DRB Application No.: 04DRB-00478 (SBP)
Project Name: CLIFFORD INDUSTRIAL PARK
Agent: Ken Hovey

CITY OF ALBUQUERQUE
PLANNING DEPARTMENT
Development Review Board

RE: Tract 49, Clifford Industrial Park/SPBP

SHEET NO.
C.1

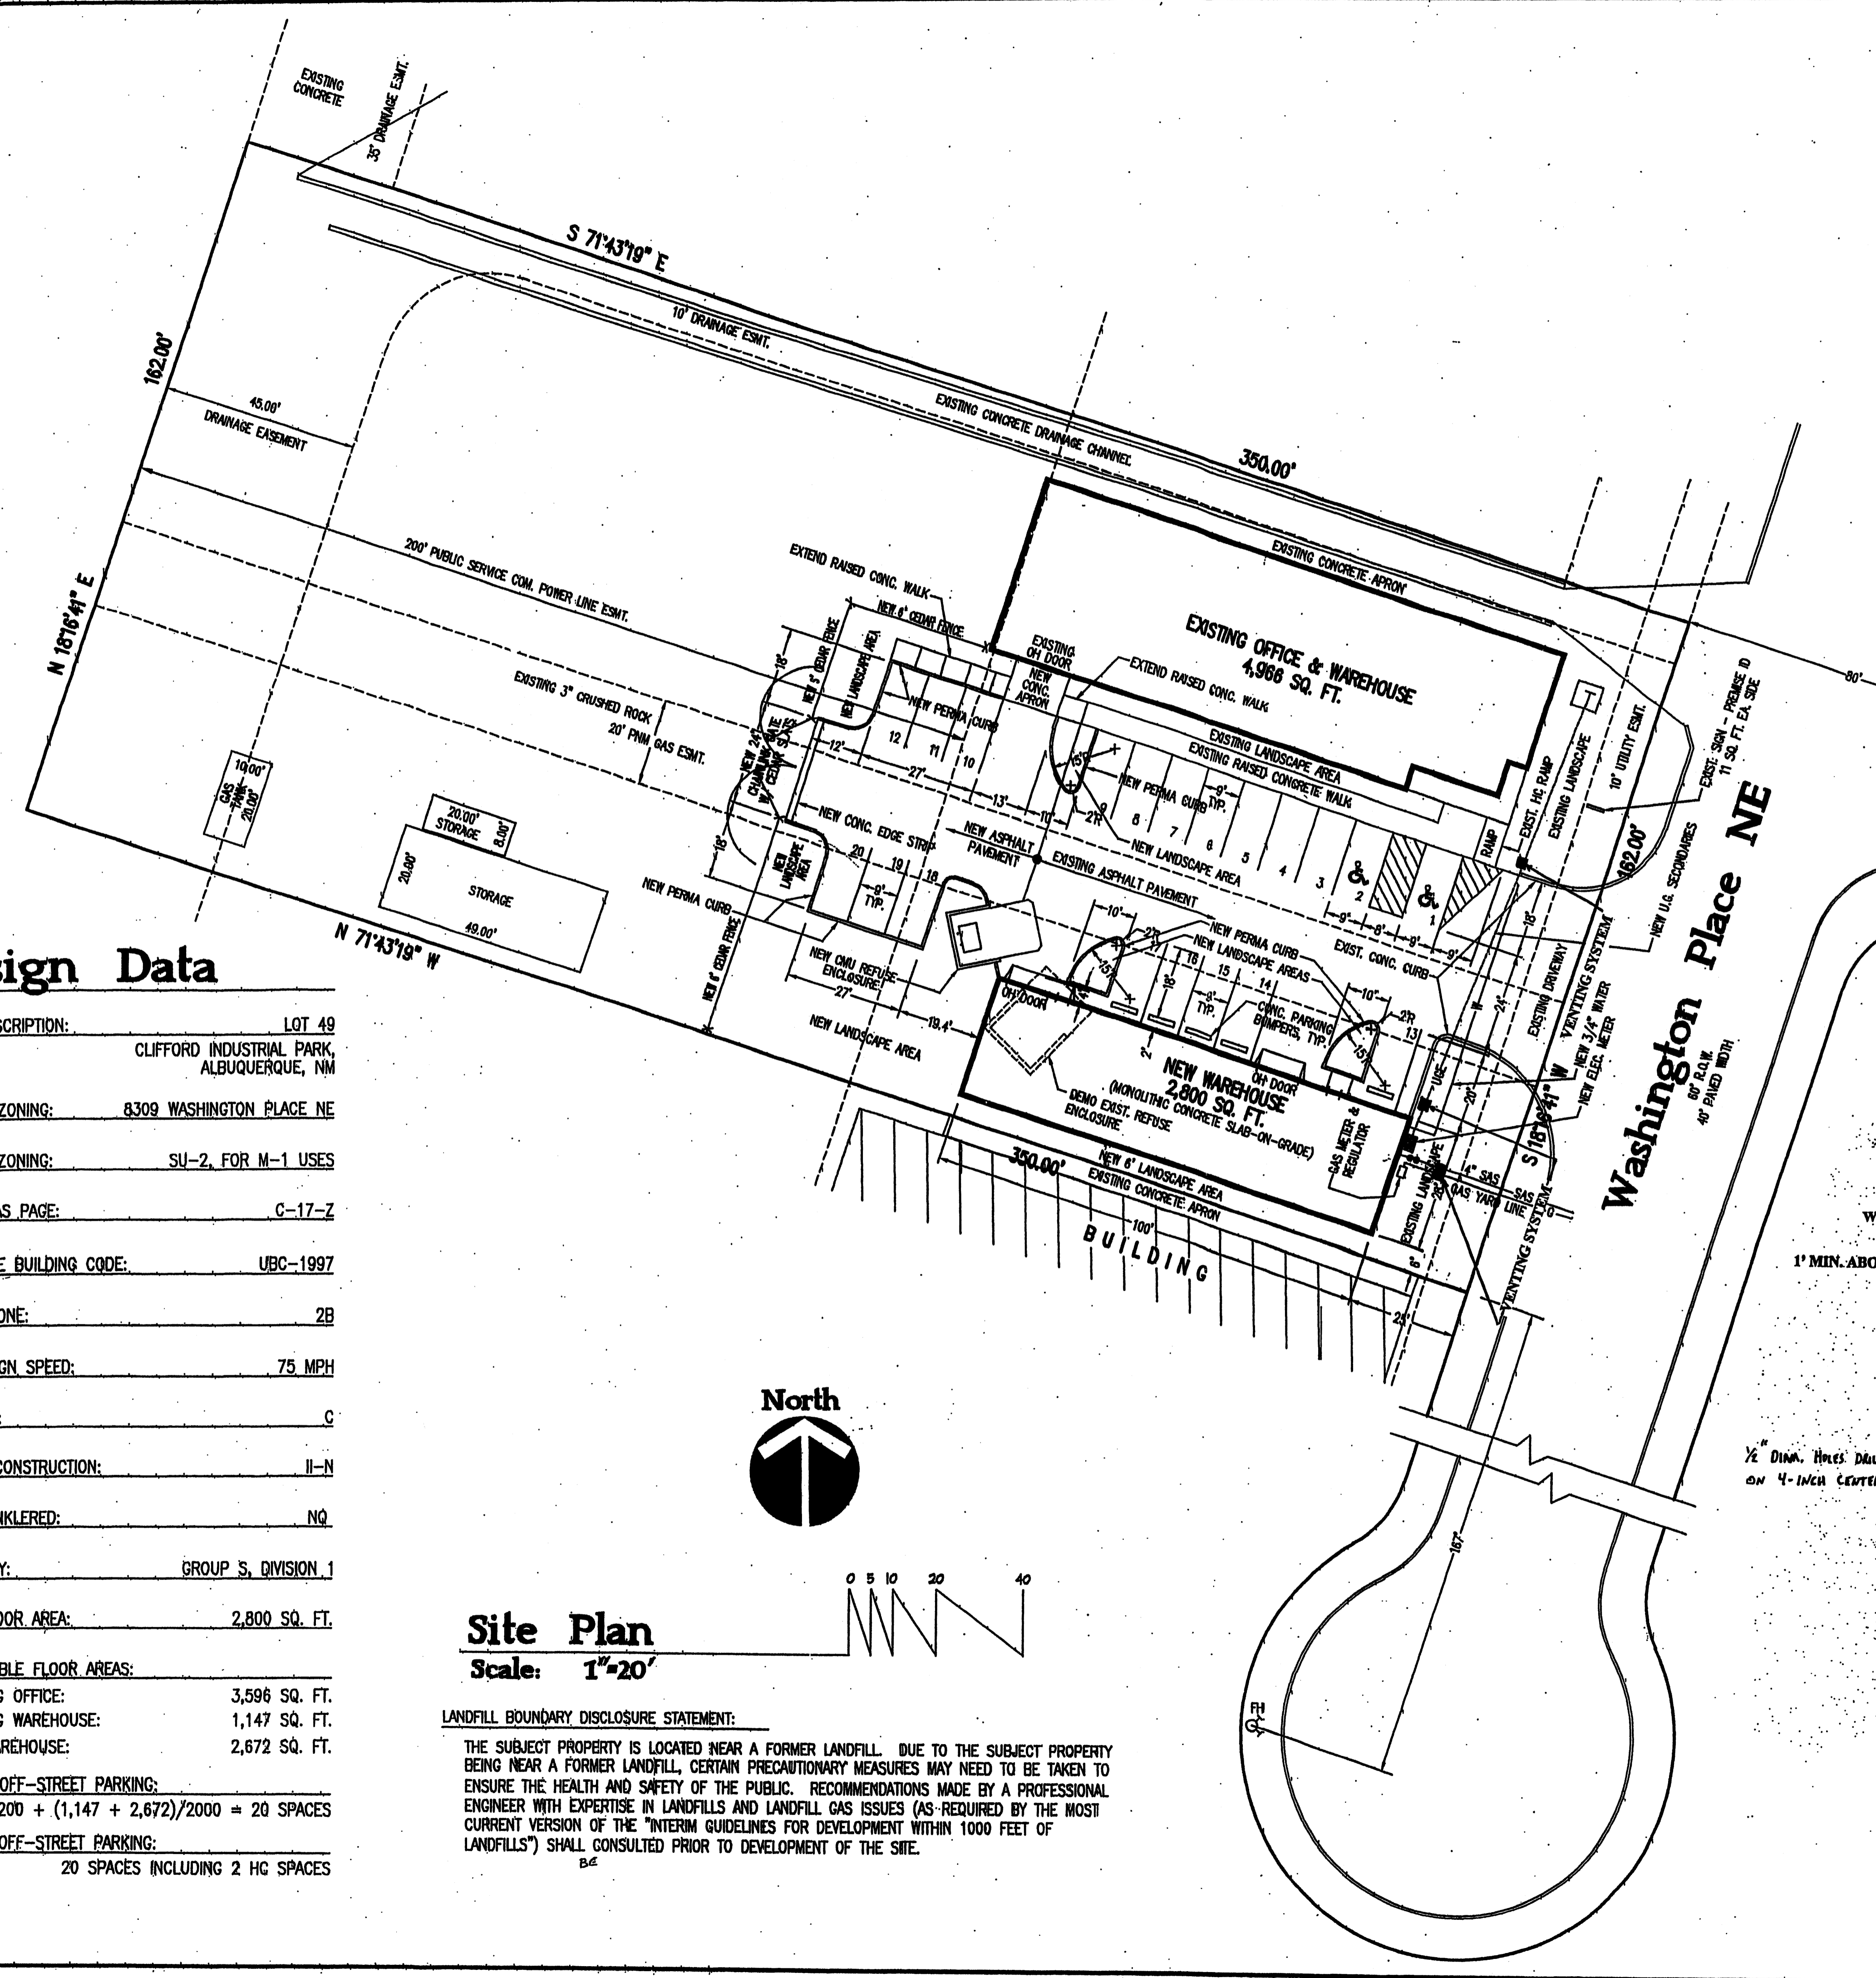
1. The property is within 1000 feet of a landfill. Therefore, a disclaimer statement is needed on the site plan and approval by AEHD of a Landfill Gas Assessment Report, etc. is required before Planning signs the site plan.

5. Setbacks: The rear yard setback should be 20 feet per 14-14-2-19 of Zone Code.

8. Are there any walls or fences proposed? Identify location, height, type, length, color & materials.

9. Site Lighting: Height & type required.

THE DISCLAIMER IS SHOWN, ENVIRONMENTAL HEALTH HAS APPROVED THE PLAN.

??!! THE REAR SETBACK IS SHOWN, IT IS NO LESS THAN

PLAN SHOWS BOTH EXISTING AND PROPOSED FENCES

THERE ARE NO FREESTANDING AREA LIGHTS,

SHEET NO.
C.1.2

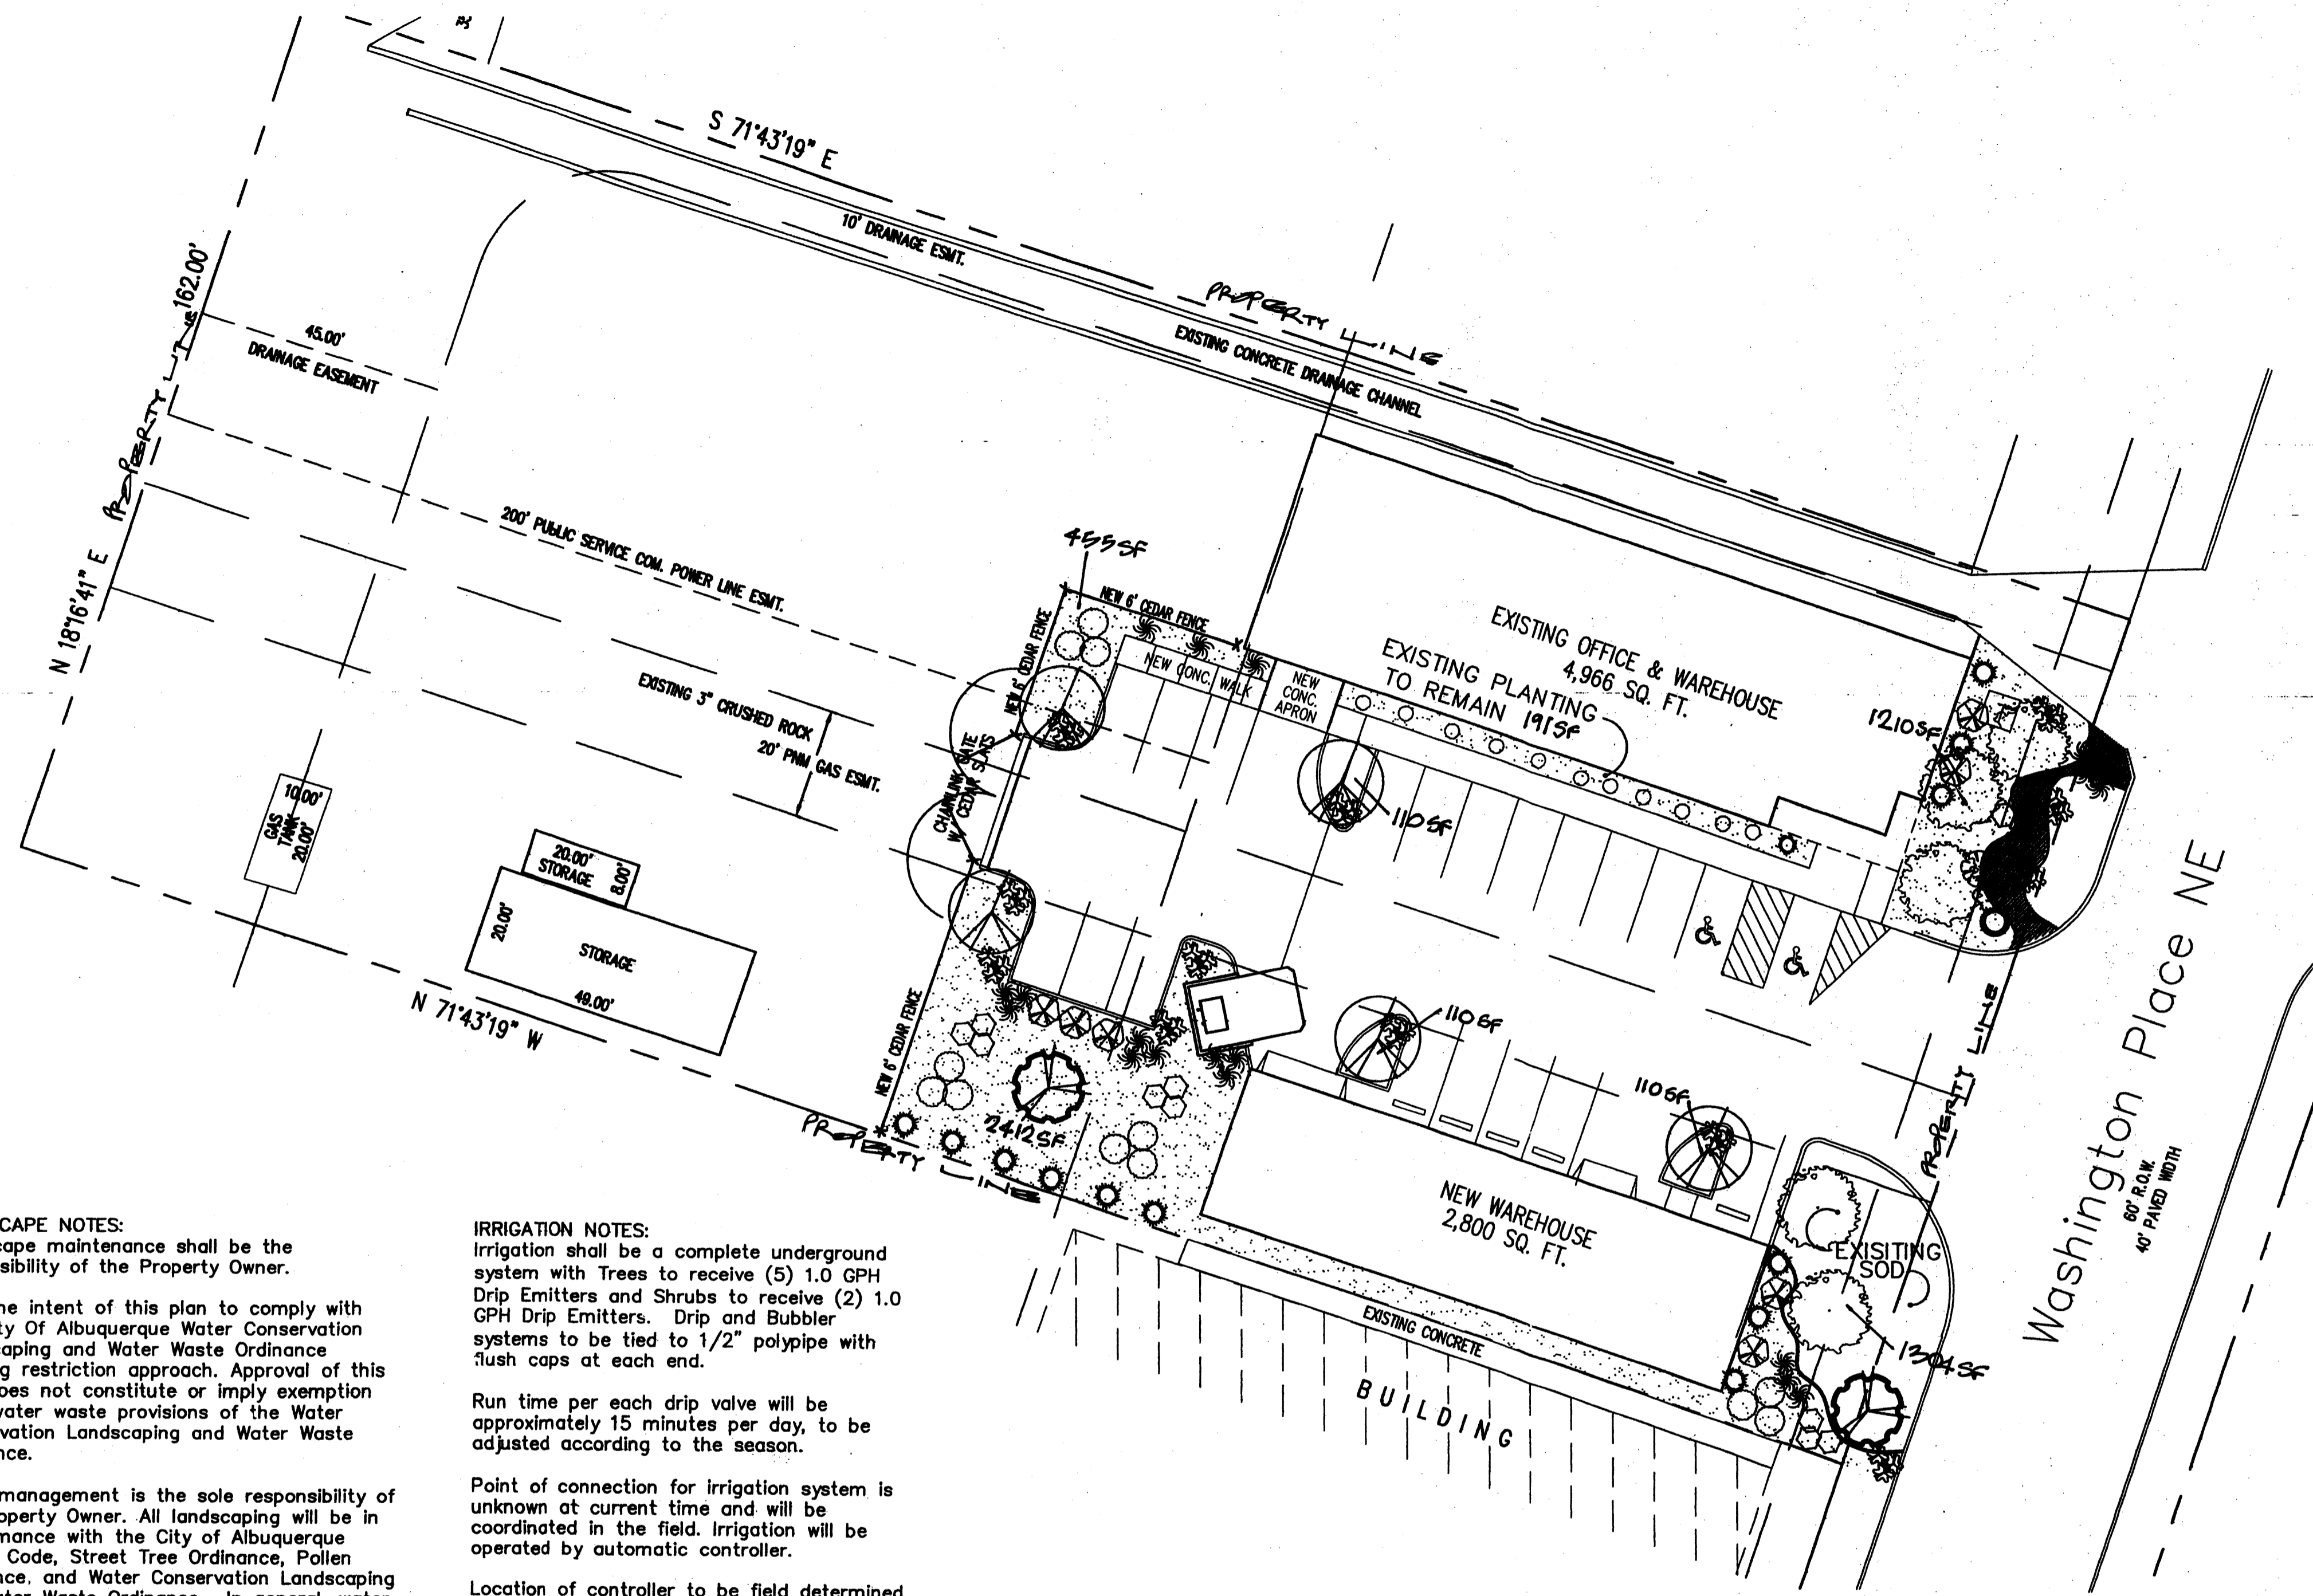
6. Landscape Plan: 225'

▪ Needs a chart showing the square footage and percent of landscaping required and provided. DONE

▪ A 6' landscape buffer along the side and rear property lines of industrial development is required per Page 54 (3)(a)1 & 2 of the North I25 Sector Plan.

IT IS SHOWN ON THE SOUTH PROP. LINE, THERE IS A 10' PRASING BASEMENT AT NORTH PROP LINE AND A 45' DRAINAGE (OVER)

EASEMENT AT THE WEST PROPERTY LINE, THERE ARE EXISTING DRAINAGE CHANNELS AT BOTH THE NORTH AND WEST PROPERTY LINES.

14-16-3-10 (E) (1) (b) PROVIDES FOR PORTIONS OF A LOT, WHICH ARE NOT REQUIRED FOR OFF-STREET PARKING AND WHICH ARE SCREENED FROM THE PUBLIC R.O.W. BY AN OPAQUE FENCE AT LEAST 6 FEET HIGH, MAY BE DEDUCTED FROM THE NET LOT AREA.

I HAVE SHOWN 13 FEET OF LANDSCAPING ON THE PUBLIC SIDE OF THE OPAQUE FENCES.
